Town and Country Planning Act 1990 (as amended)
Proposal for Erection of up to 41 Dwellings, Land off School Lane, Forton
Planning Application Number: 20/01296/OUTMAJ

I refer to the report entitled 'Contaminated Land Phase One Desk Study for Clifton House Farm, Clifton Hill, September 2016'. The report has been prepared by Martin Environmental Solutions on behalf of Graham Anthony Associates.

Previous Correspondence

Client Ref: Graham_Anthony_Associates
Report Ref: GS-3257697
Grid Ref: 348450, 451296

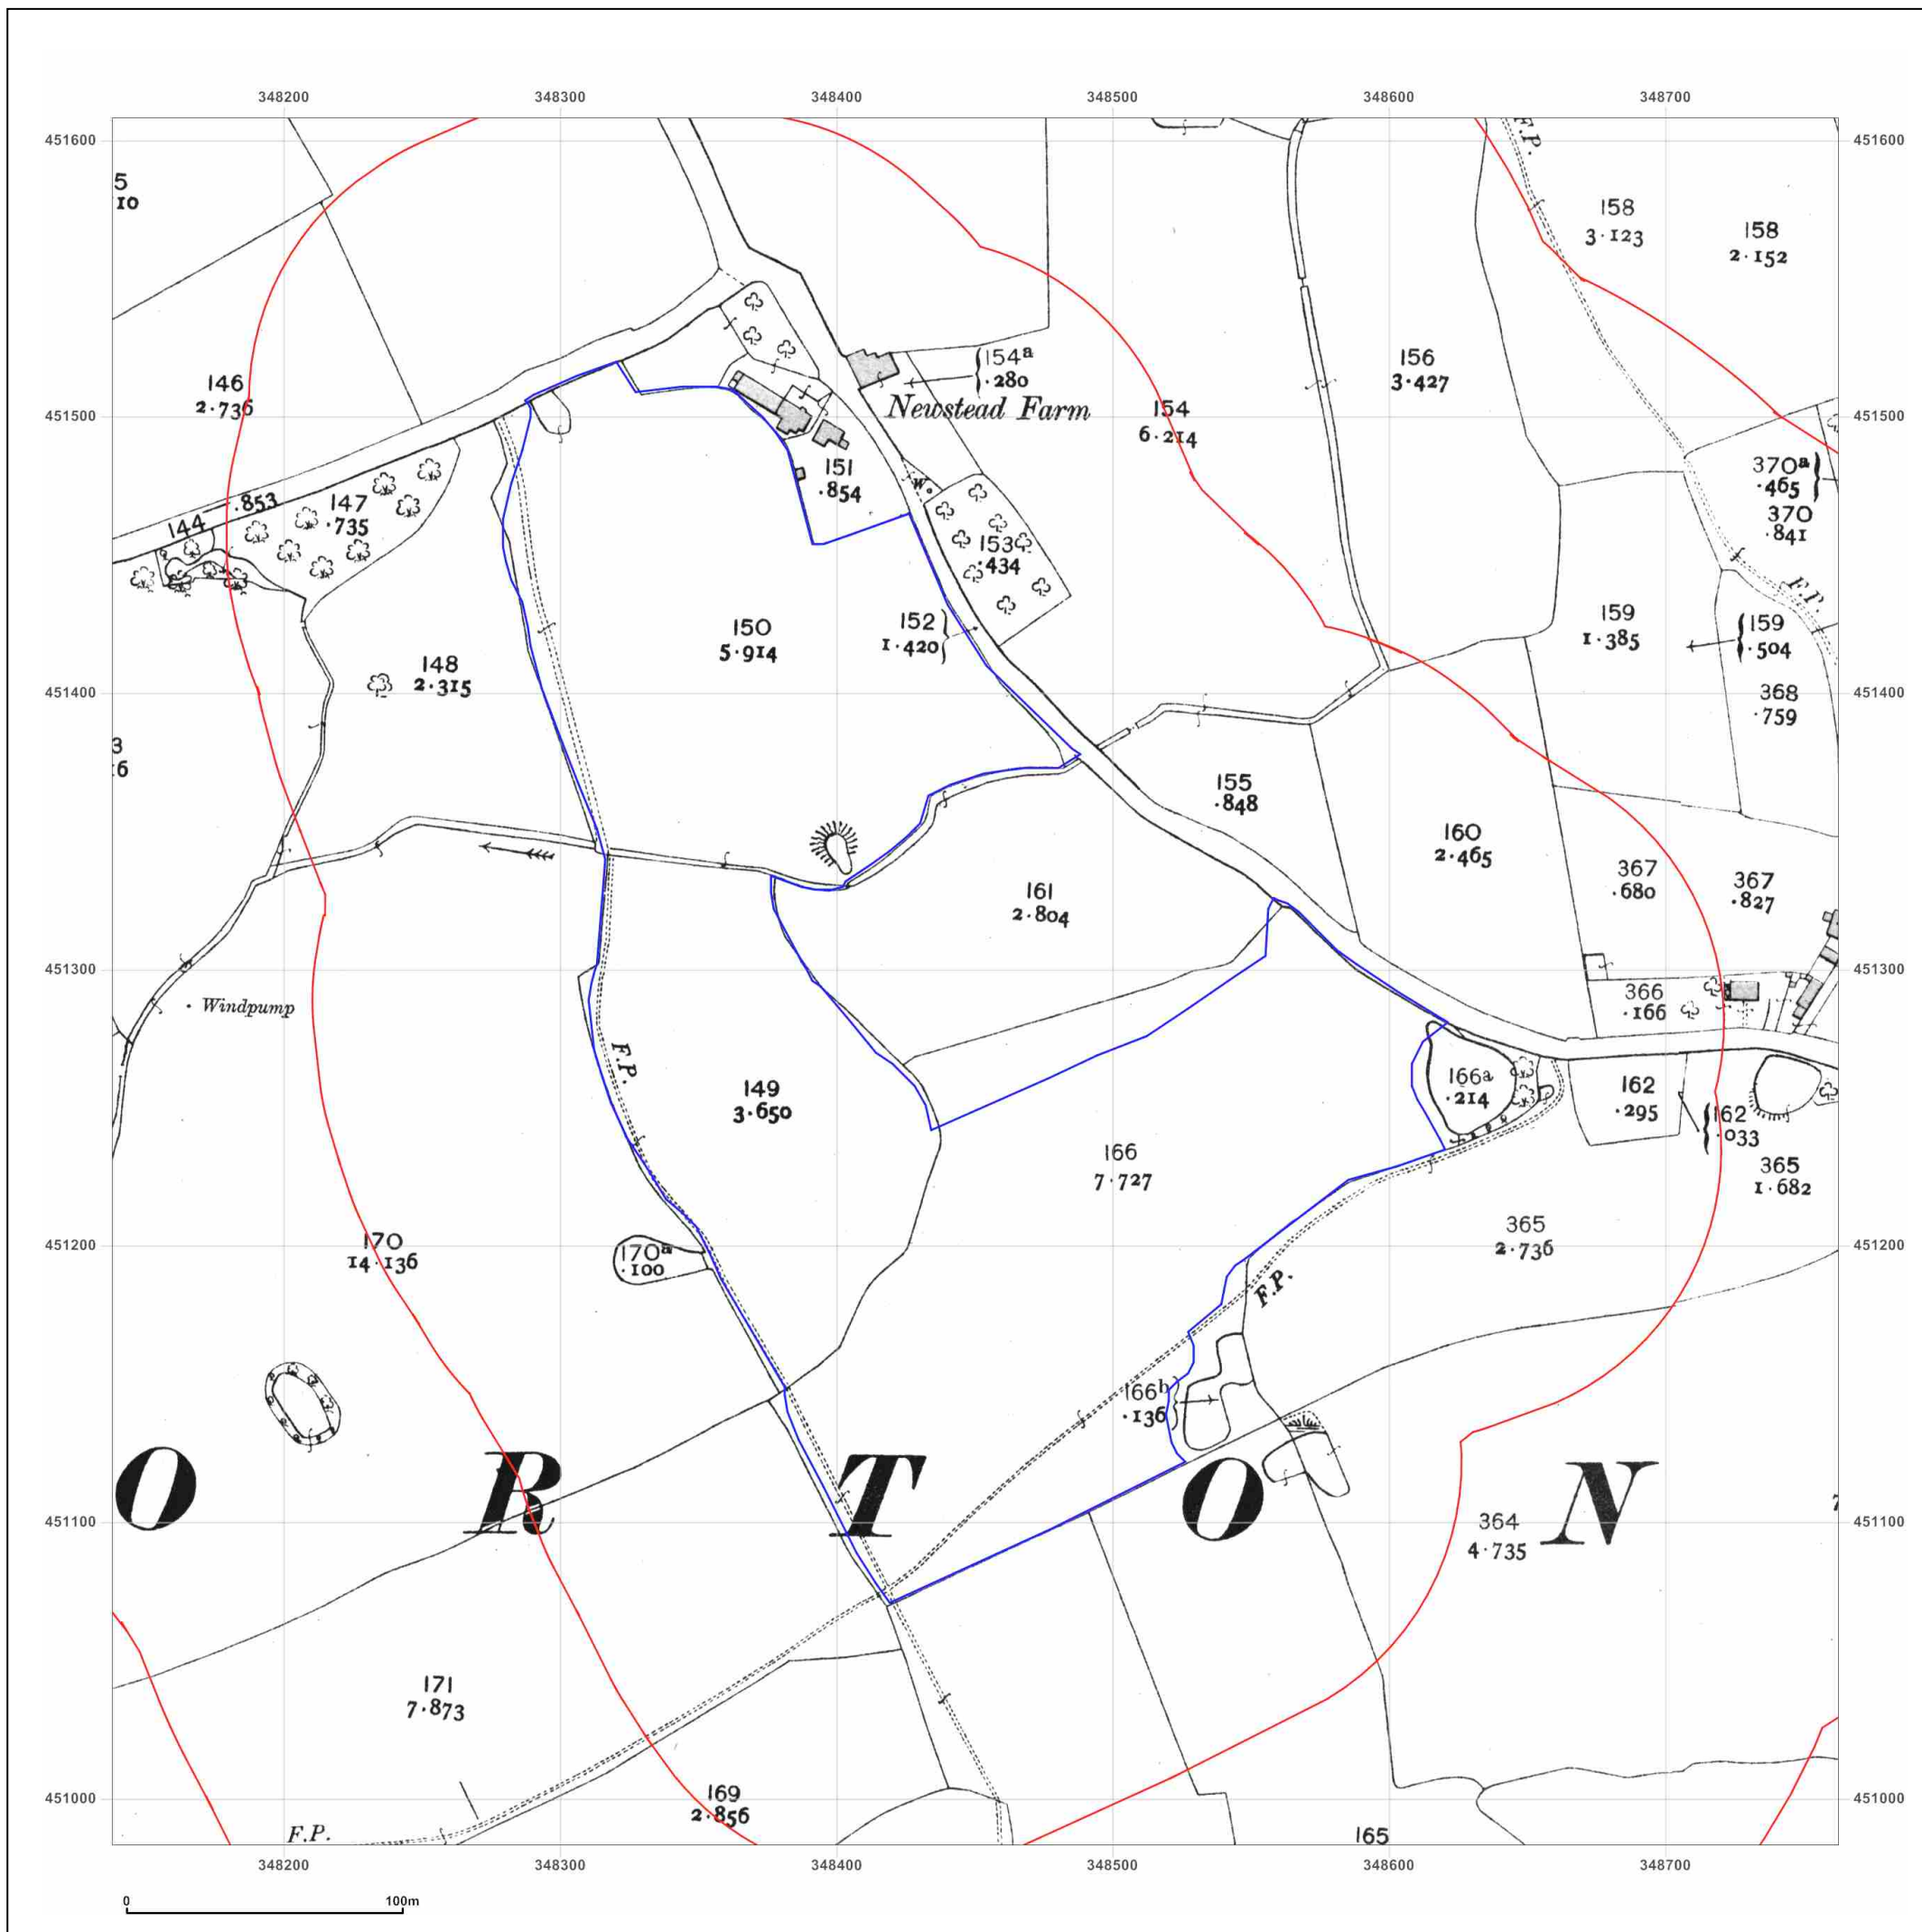
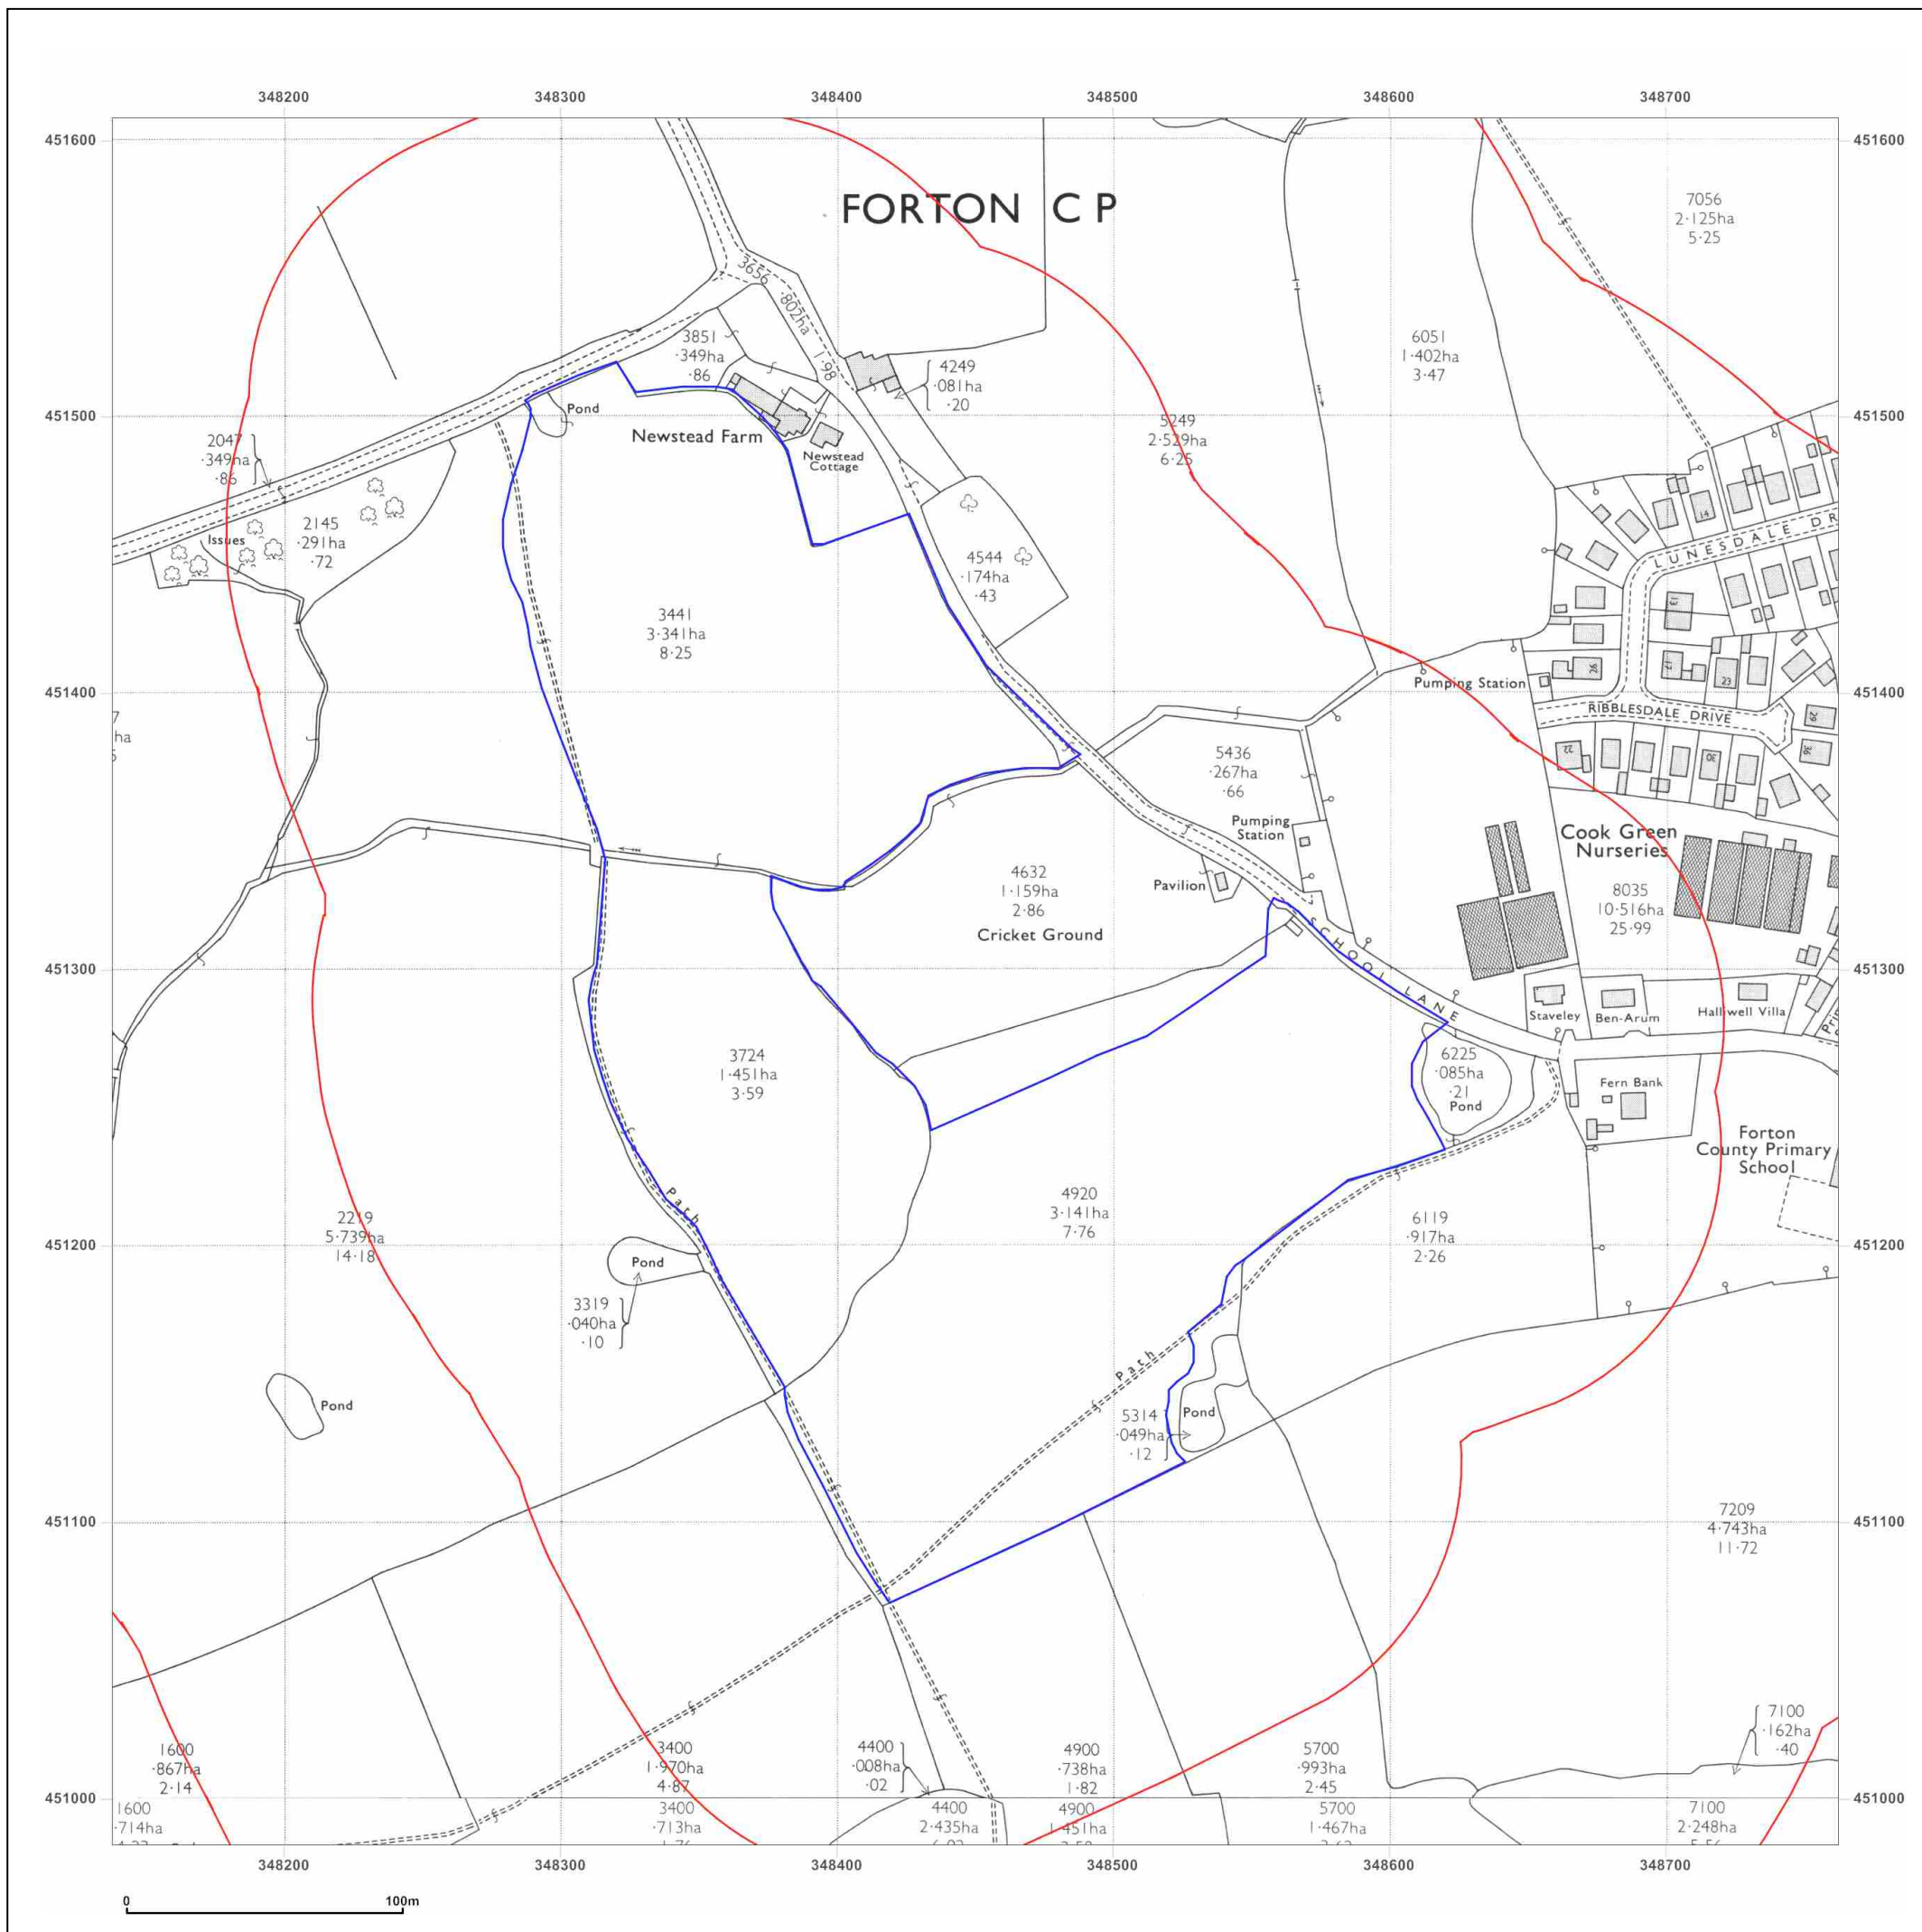
Finally, it is possible that some historical maps are missing from the copy of the report available on line. There is a download for 'appendix 2 historical maps', but the link is for an Ecological Appraisal.

- Please confirm if there are any other historical maps available for review which haven't been uploaded onto the Wyre BC planning portal.
